Appeal Decision

Appeal Ref: 6003599

24 Sweetcroft Lane, Uxbridge, Hillingdon UB10 9LD

- The appeal is made under section 78 of the Town and Country Planning Act 1990 (as amended) against a refusal to grant planning permission.
 - The appeal is made by Z Gazi against the decision of the Council of the London Borough of Hillingdon.
 - The application Ref is 13272/APP/2025/1976.
 - The development proposed is retrospective planning application for the retention of a new entrance porch and single storey front projection, providing a uniformed mono-pitched roof to the front elevation.
-

PROPOSED FRONT ELEVATION
SCALE 1:100

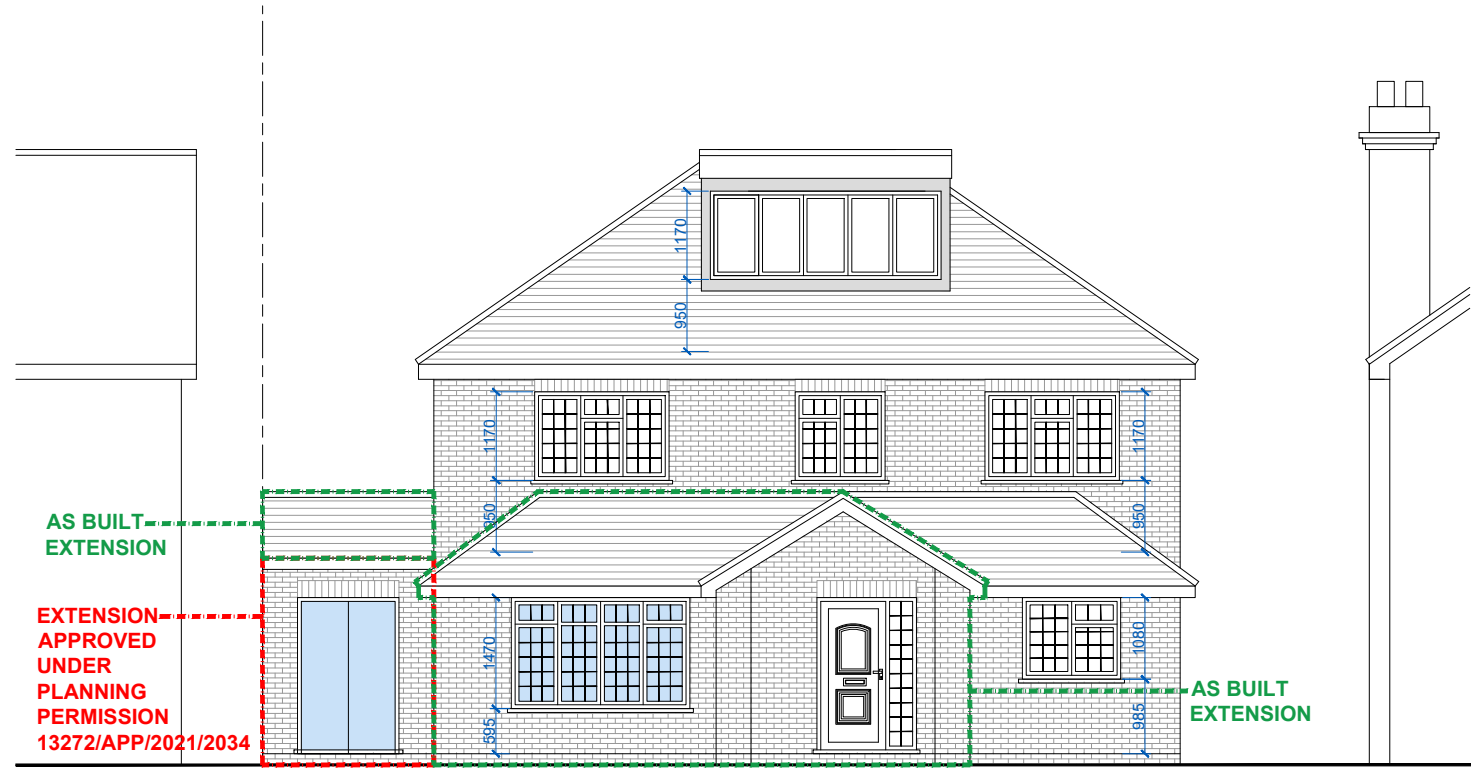
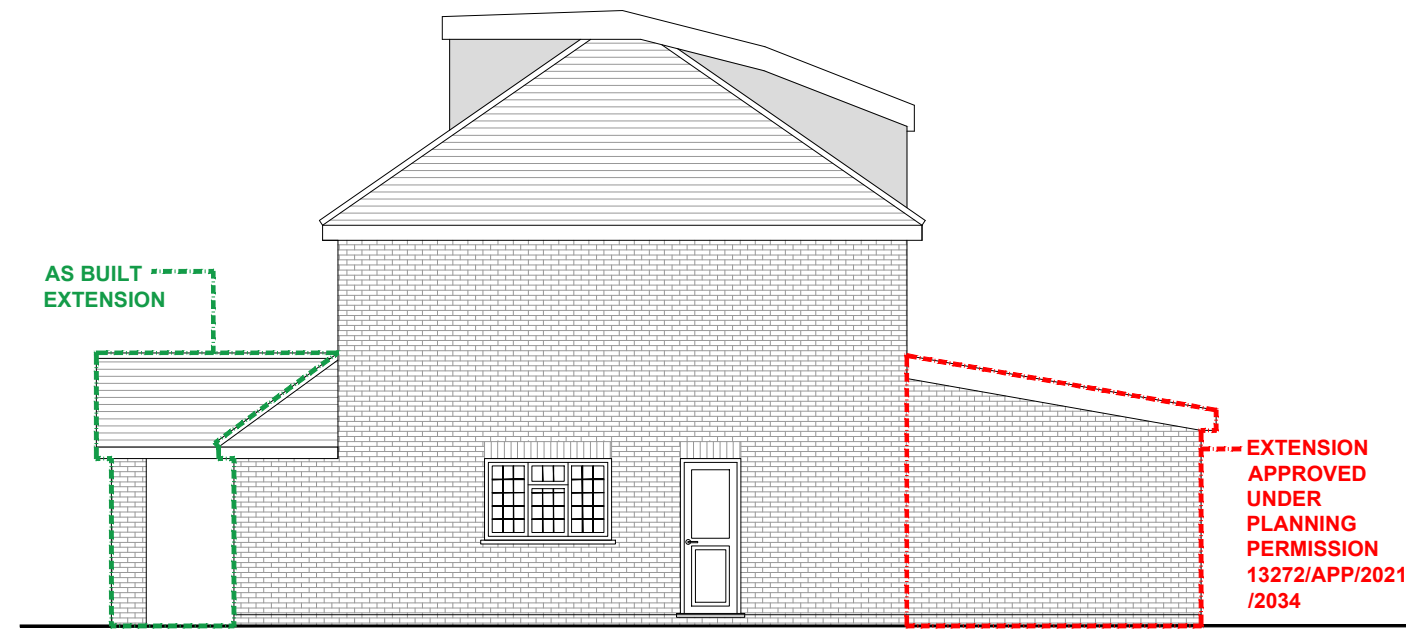
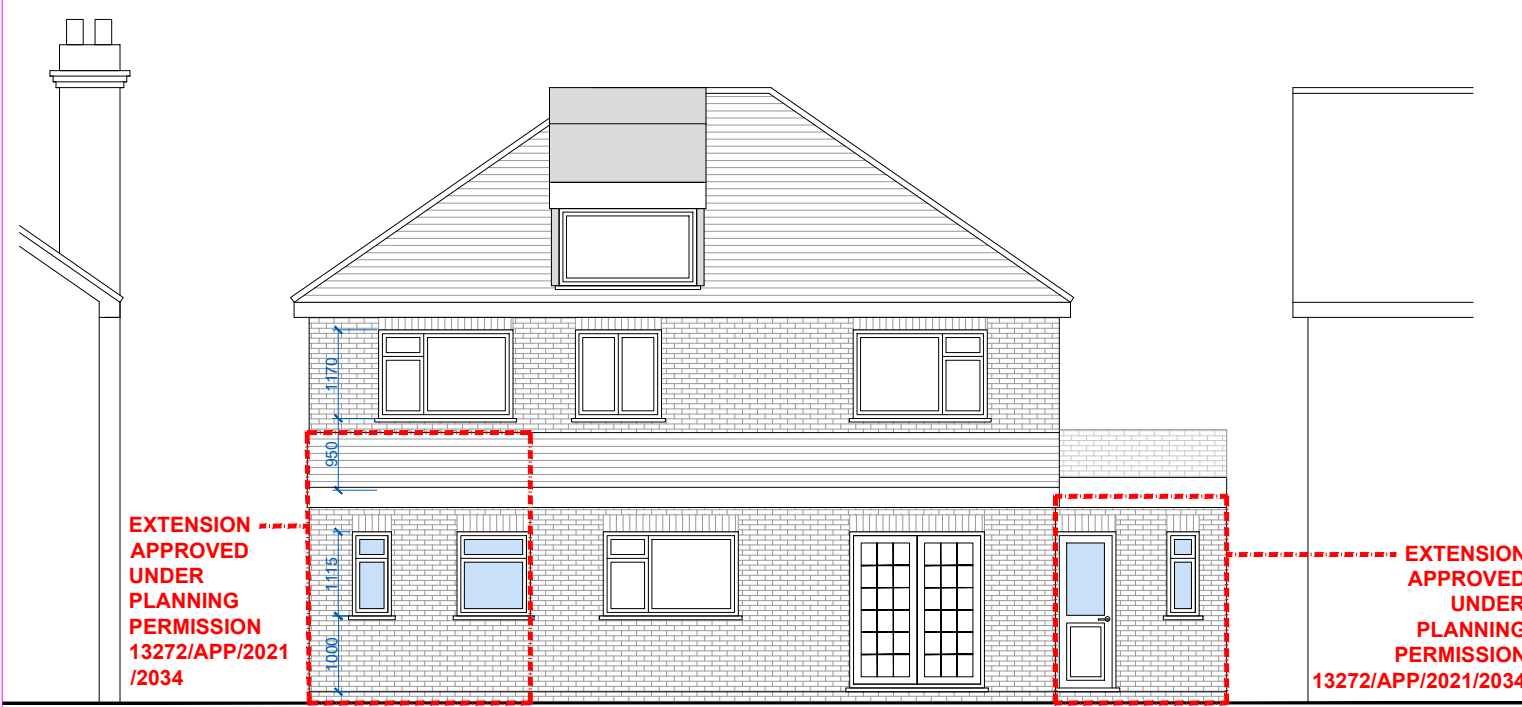
9. The appeal development relates to an extension which spans part of the front elevation. It also includes a projecting porch canopy. Together with an existing front projection at the dwelling, this creates a front projection which spans most of the width of the front of the dwelling, albeit notably does not extend across the existing single storey side addition.

10. The appeal development corresponds well to the overall design of the dwelling in both materials and roof design. Despite local concerns, I find that although the porch canopy extends beyond the front building line, its modest height and generally open appearance reduces its overall prominence. When taken in the context of the rest of the dwelling, the appeal development is subordinate and does not significantly alter the overall appearance of the dwelling.

11. The immediate street scene displays a variety of similar single storey front projections. Rather than being more modest in size in comparison to the appeal development, I observed during my site visit that the sizes and designs of the projections vary considerably. The appeal development therefore assimilates well with the overall character of the street scene.

1. The appeal is allowed and planning permission is granted for a new entrance porch and single storey front projection, providing a uniformed mono-pitched roof to the front elevation at 24 Sweetcroft Lane, Uxbridge, Hillingdon UB10 9LD in accordance with the terms of the application, Ref 13272/APP/2025/1976, and the plans submitted with it.
